**Re: PNM - Sagebrush Substation – 3000 University Blvd. SE
ESC Plan Engineers Stamp Date: 1/6/2022 – M15E049**

Based upon the information provided in your submittal received on 5/27/2022 and 6/2/2022, the above-referenced ESC Plan can't be approved for Grading or Work Order until the following comments are addressed;

James D. Hughes

EROSION CONTROL PLAN

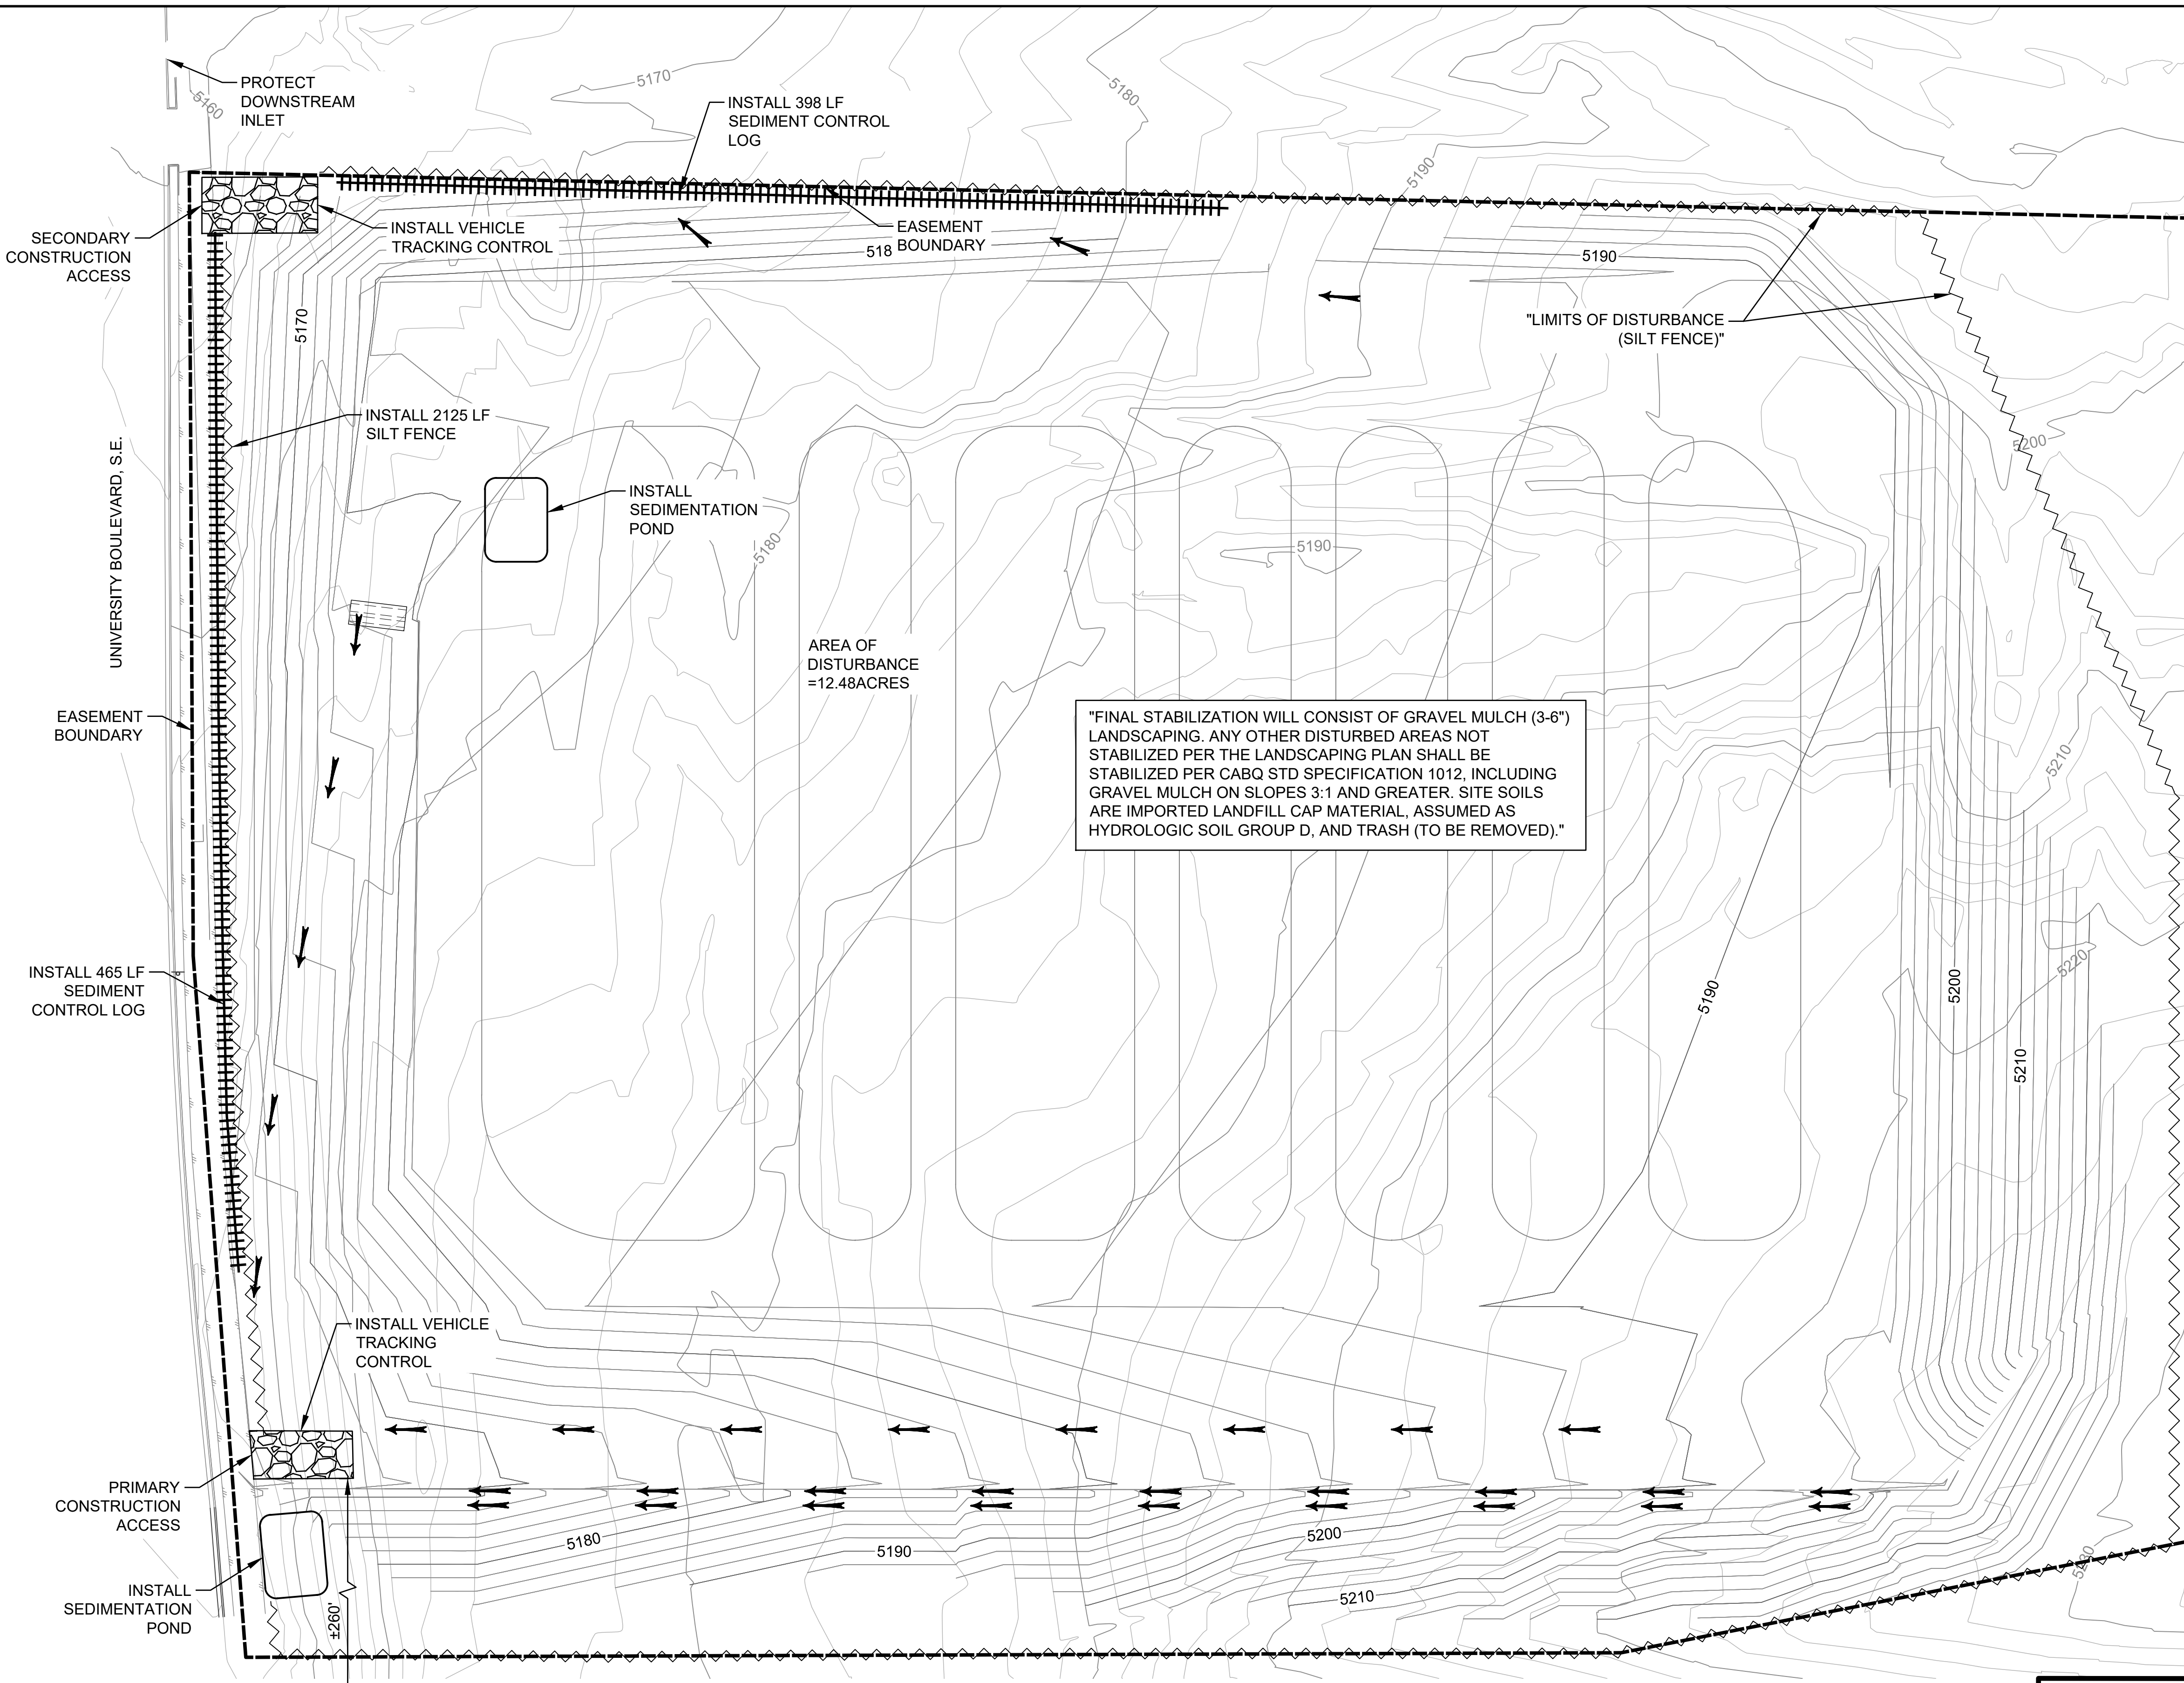
1. Identify locations of concentrated flow paths that enter and exit the disturbed areas. Identify locations where sheet flow enters and exits the disturbed area. Show on-site drainage patterns of stormwater before and after major grading activities (CGP7.2.4.f);

2. Two sediment traps are schematically shown on the ESC plan, but design calculations and construction specifications are missing. Use erosion controls and velocity dissipation devices to prevent erosion at inlets and outlets and provide site specific volume calculations and grading specifications (CGP 2.2.12). Construction of the south temporary sediment trap on the side of the existing slope is problematic and should be specified in more detail.

4. Provide specifications to insure runoff in the two concentrated flow paths will be directed to appropriately sized BMPs without being discharged through the south construction entrance.

5. Update the engineer's stamp date each time the plan is changed.

PLANTING PLAN

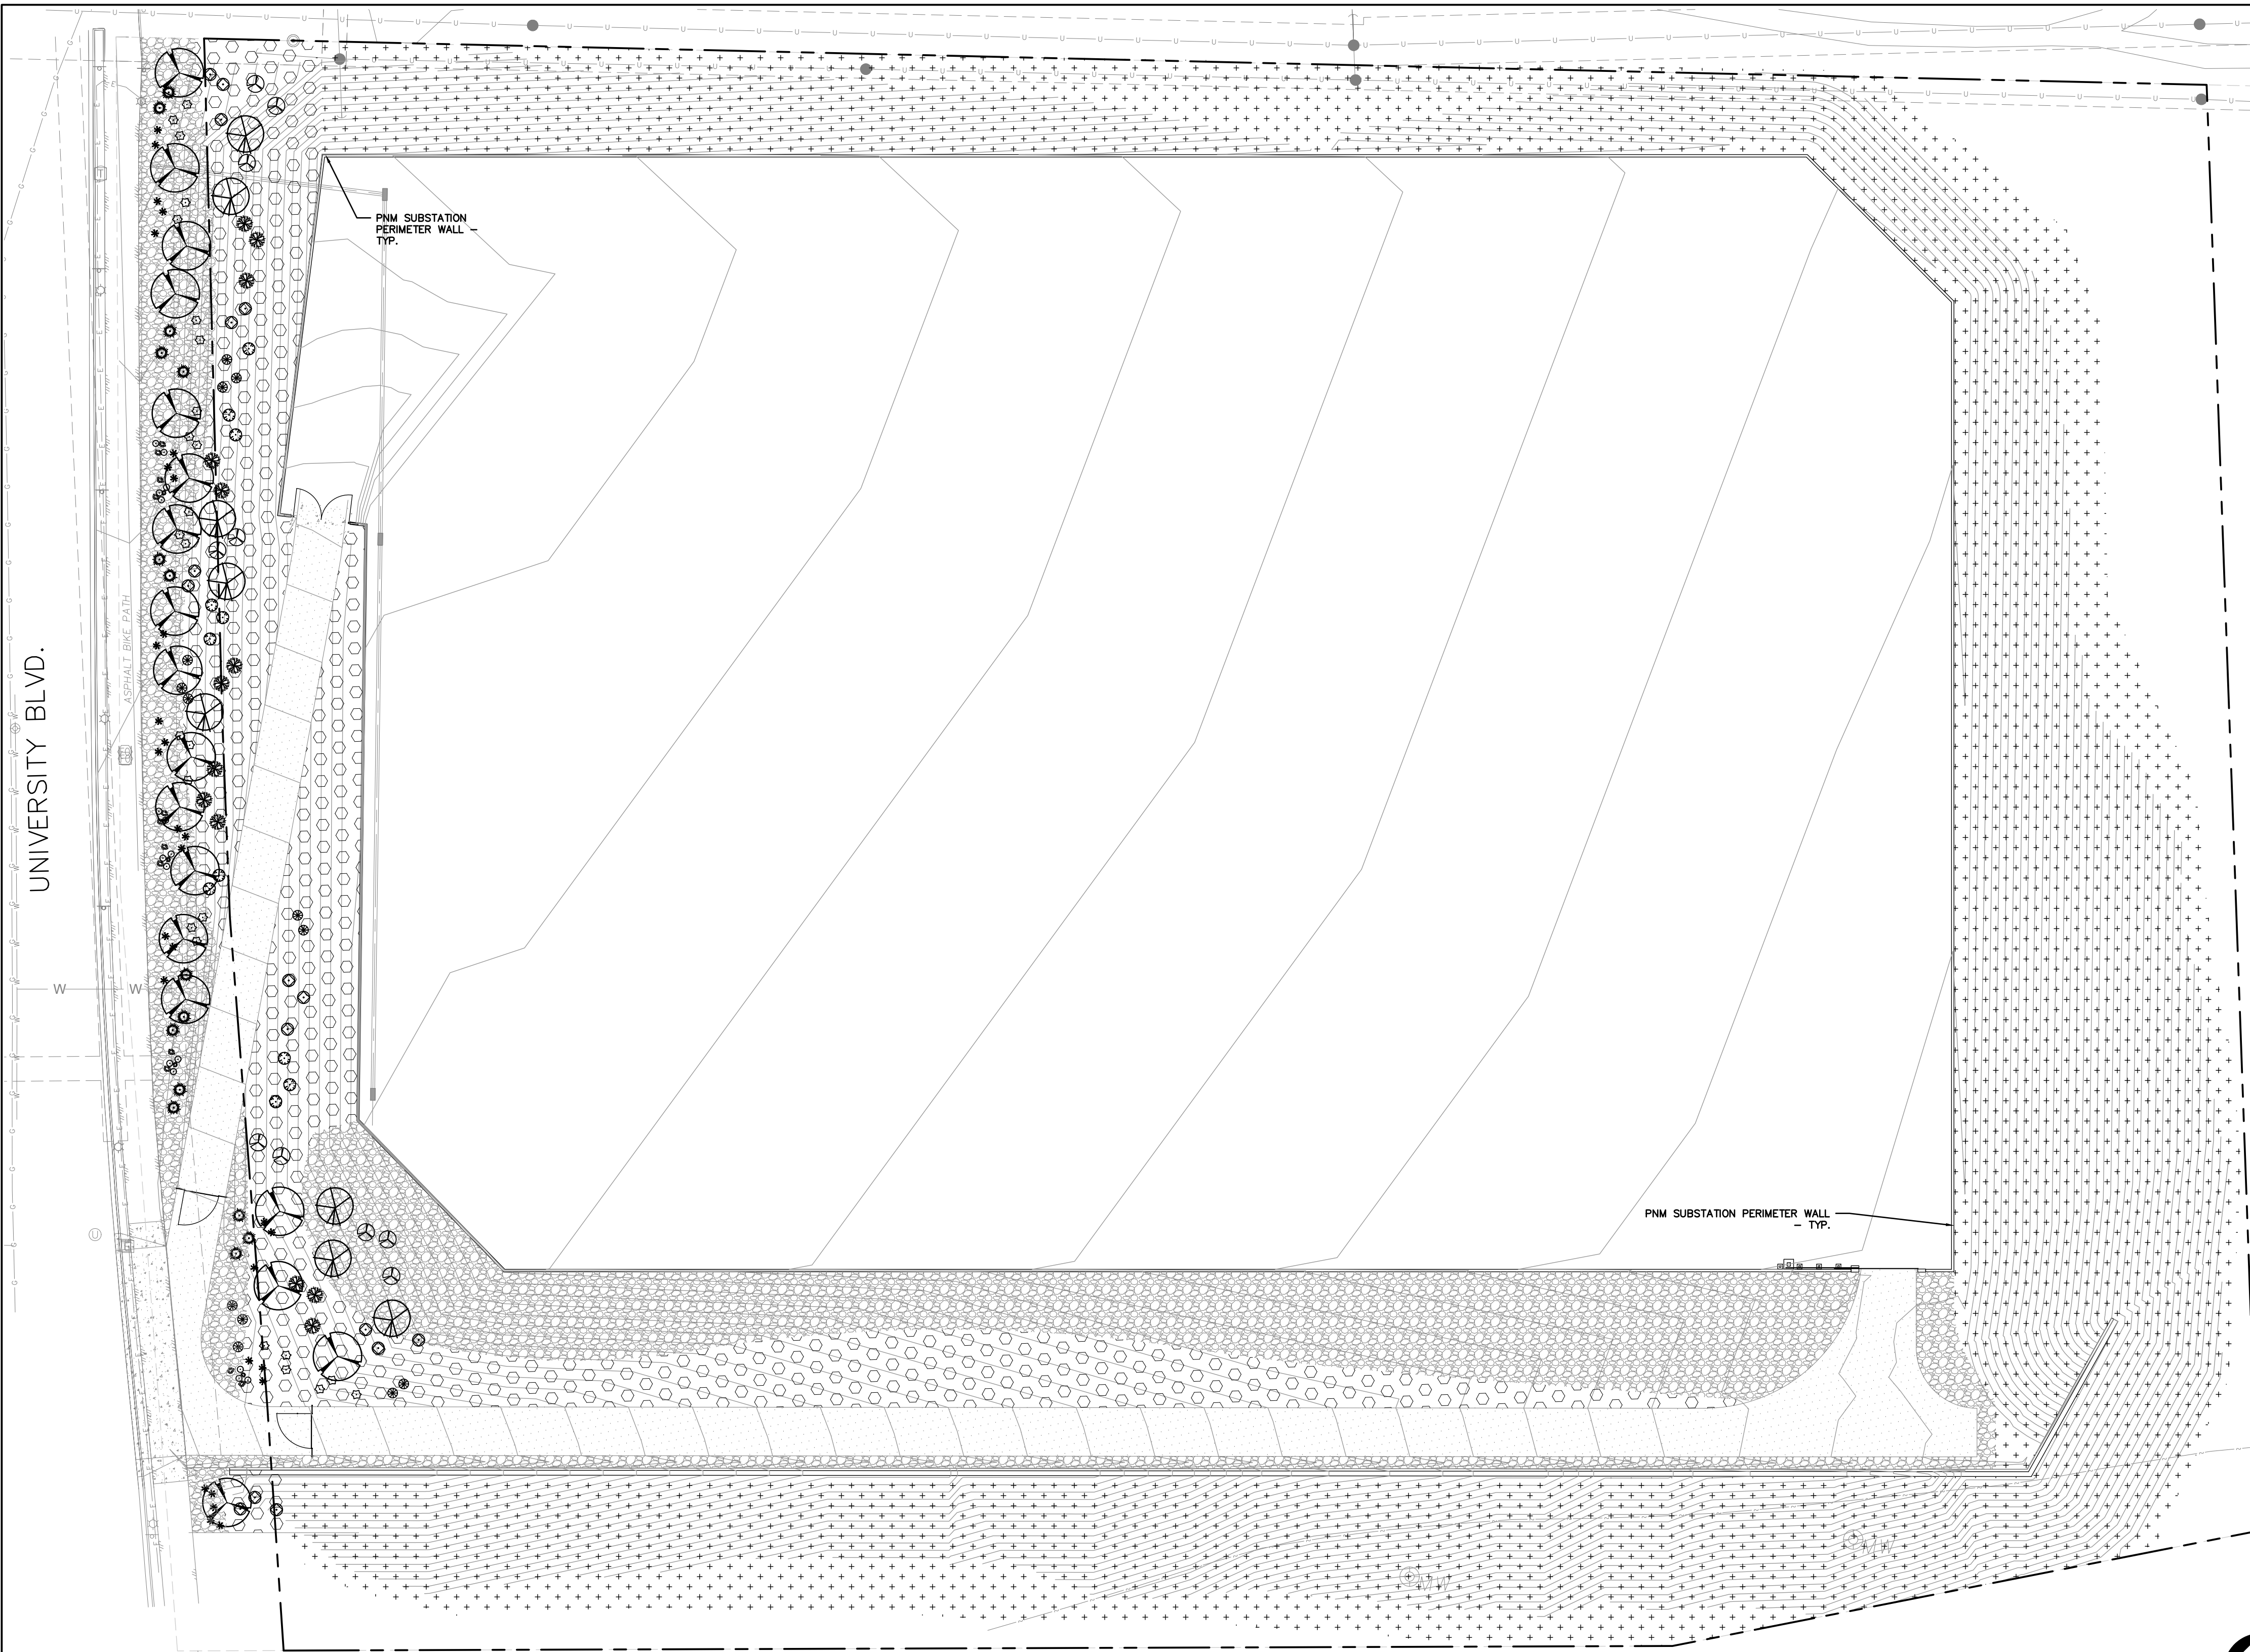
3. The SWPPP must include site-specific interim and permanent stabilization per CGP 9.4.1.c.i. The Landscape Plan and Work Order sheets can be used to satisfy this requirement and should be submitted separate from the ESC Plan with the application to the Stormwater Quality Section of the Planning Department and they should be included in the SWPPP. Differentiate between the various types of vegetative and non-vegetative stabilization measures and include rip-rap specifications for the two concentrated flow paths (ditches) adjacent to the two steep onsite driveways (CGP 2.2.14.c). Identify specific locations where vegetation will be used to satisfy the Final Stabilization Criteria.
